PULTE APS DEVELOPMENT TRAFFIC IMPACT ANALYSIS

INITIAL SUBMITTAL

January 20, 2025

Bohannon Huston, Inc.

Trip Distribution Percentages are shown in Figure 3.

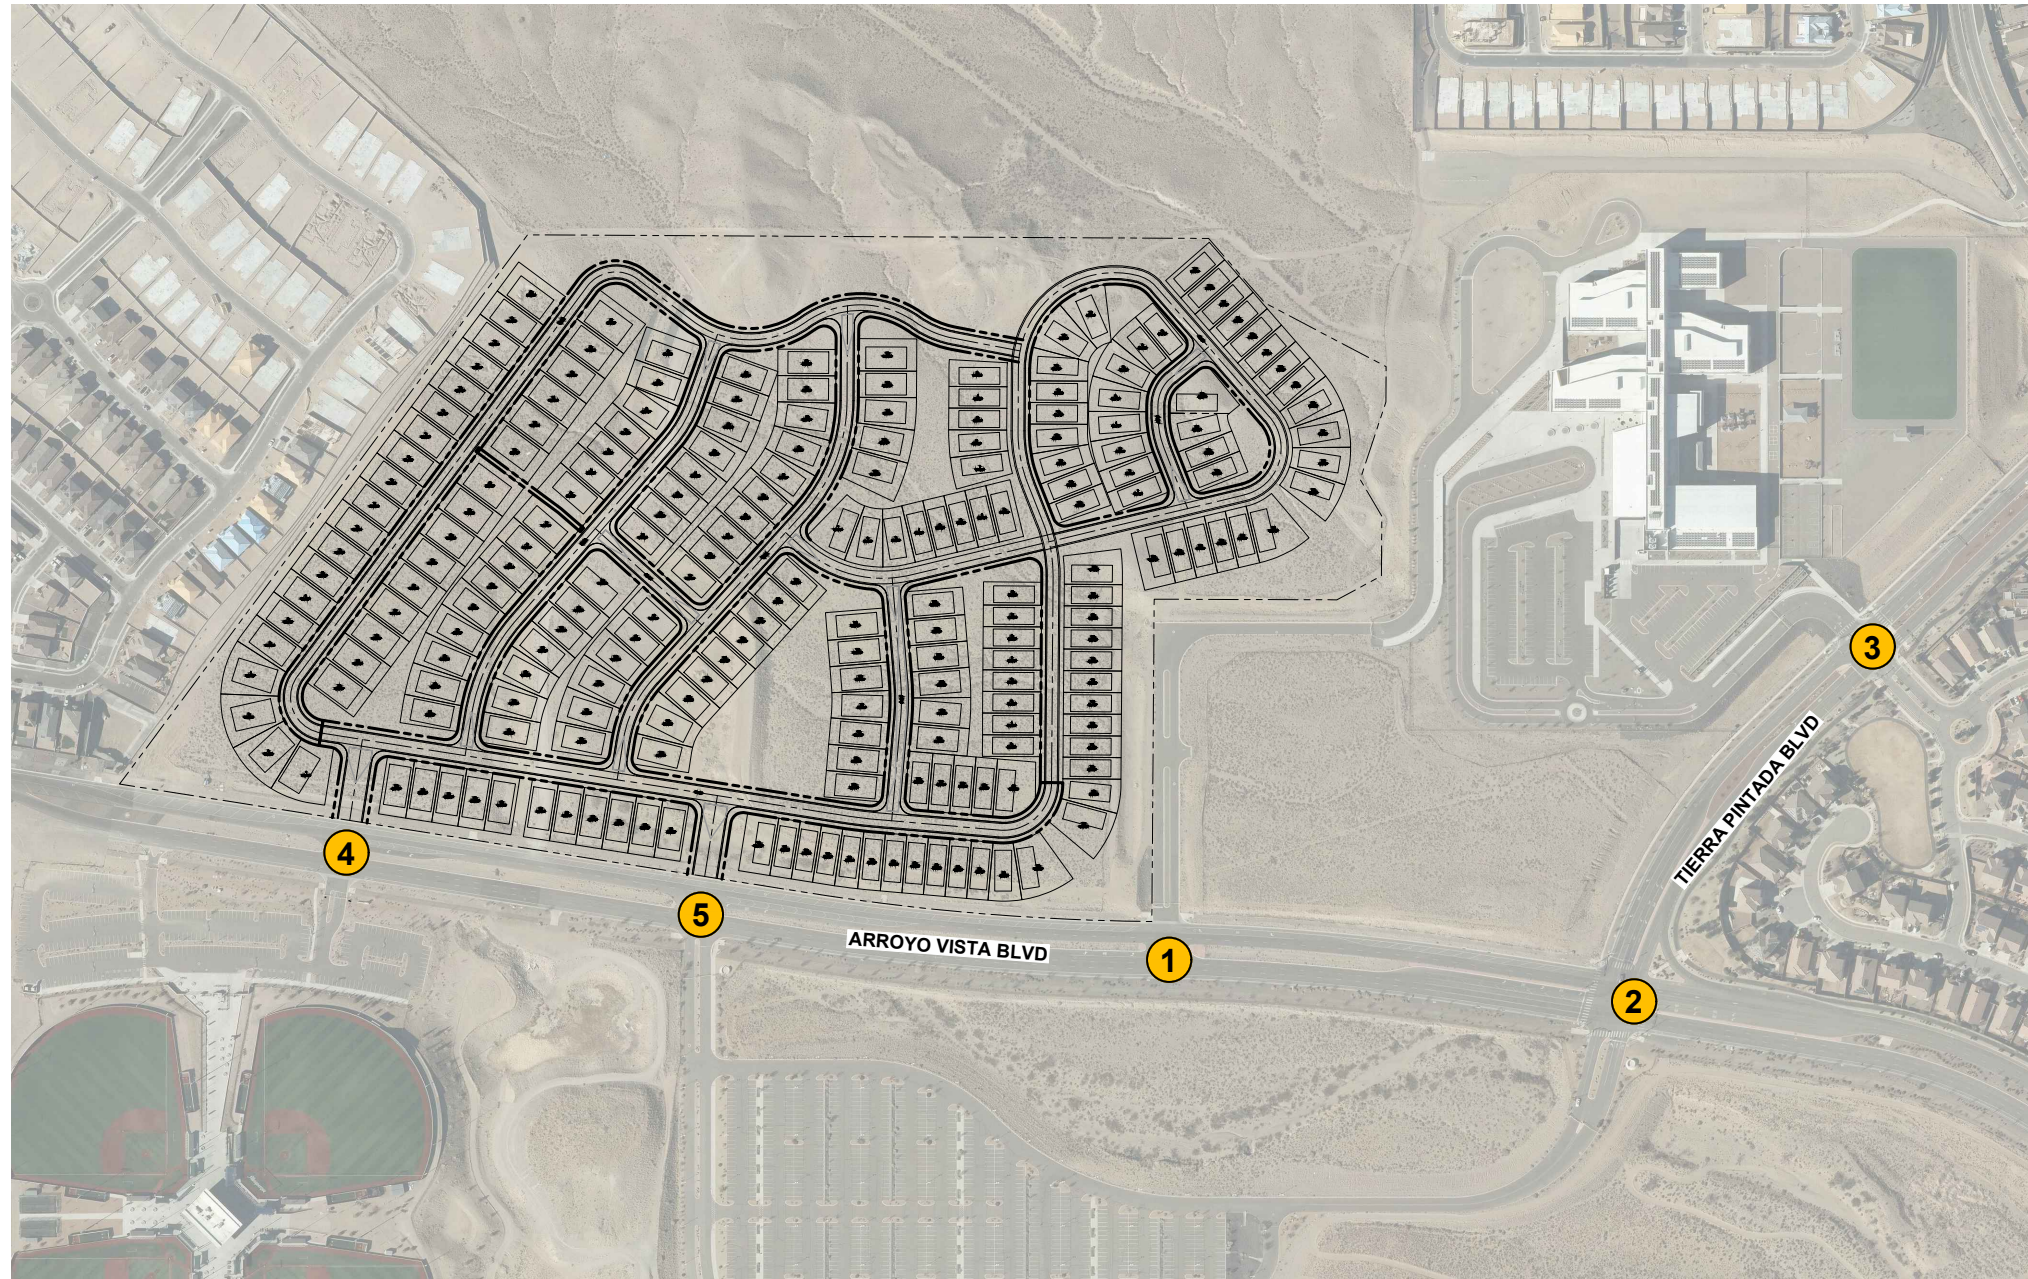
Update all %
entering and
exiting based on
updated TMC

Update all %
entering and
exiting based on
updated TMC
